Our Case Number: ABP-310286-21

Re: Railway works and all works necessary to eliminate and, where necessary, upgrade seven numbered level crossings and carry out all associated and ancillary works along a 24-kilometre section of the Dublin to Cork Railway Line.
Fantstown, Thomastown, Ballyhay, Newtown, Ballycoskery (Ballyhea Village), Shinanagh and Buttevant, Co. Cork and Co. Limerick.

RE: Railway Order – Dublin to Cork Railway Line (Eliminate and Upgrade of Level Crossings between Limerick Junction and Mallow) Order 2021 – XC201 Thomastown

Figure 2.5: XC201 Thomastown Proposed Route Alignment

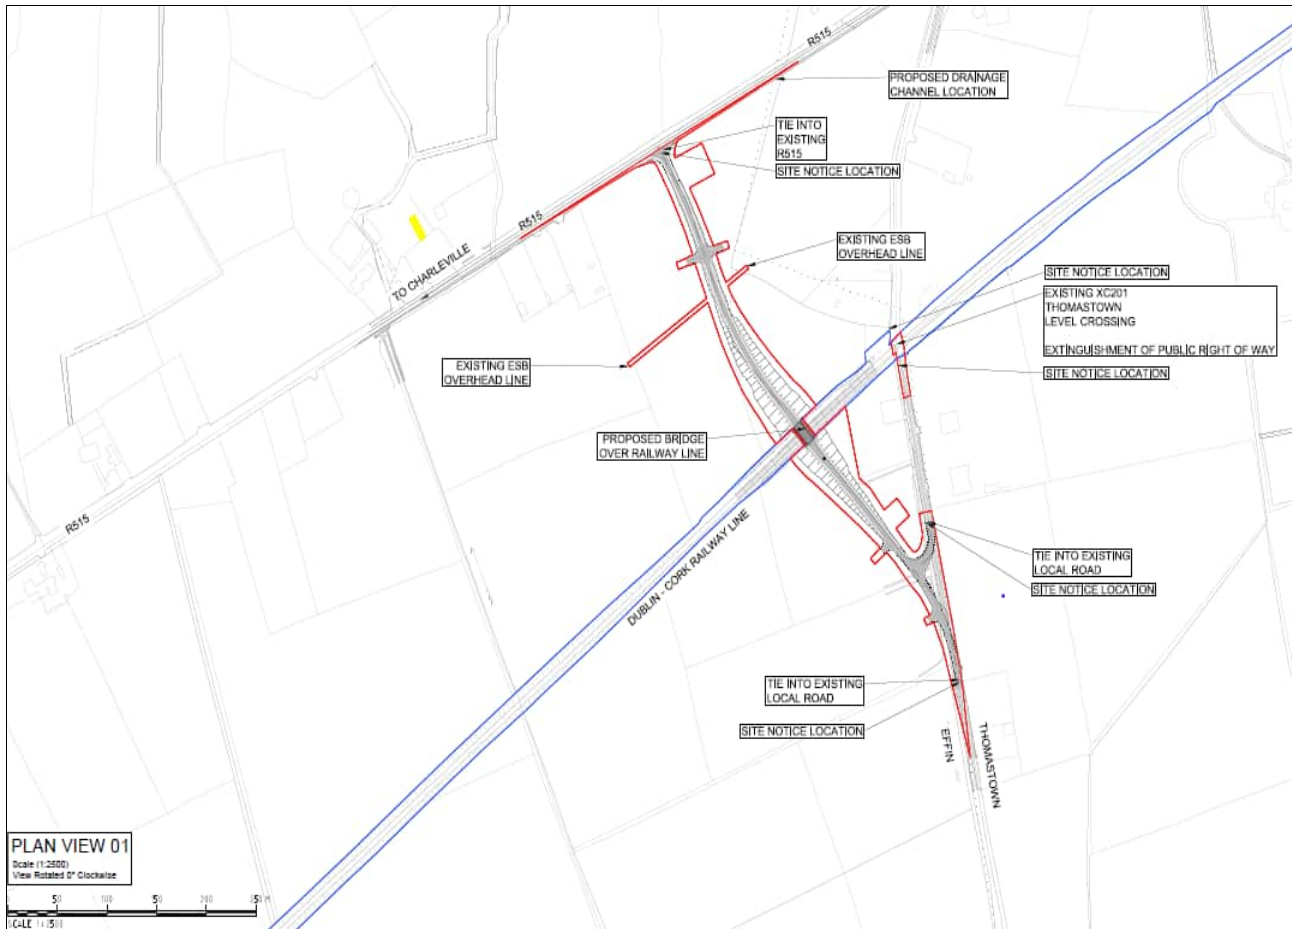
1. Width of the road – The new road will not be wide enough for two vehicles to pass safely i.e. cars, trucks & farm machinery
2. The new junction on to the main Charleville, Kilmallock road (R515) is designed in an unsafe way as it will cause stacking of cars when a vehicle is turning off the R515 onto the new road.

3. The Parish of Effin has been divided for many years by the railway line and gates at the level crossing which are always closed to vehicles. All the amenities of the Parish are on the southern side of the railway line (i.e. primary school, GAA facilities, church etc.). This new road is a major step forward in uniting what was a divided Parish and the volume of traffic will increase tenfold at a minimum as a result of this proposed development and therefore in the interest of health and safety for road users a two lane road is essential.

4. As we are a farming community the volume of agricultural machinery will also increase on this road especially during the busy harvesting season which further outlines the importance of having a two lane road.
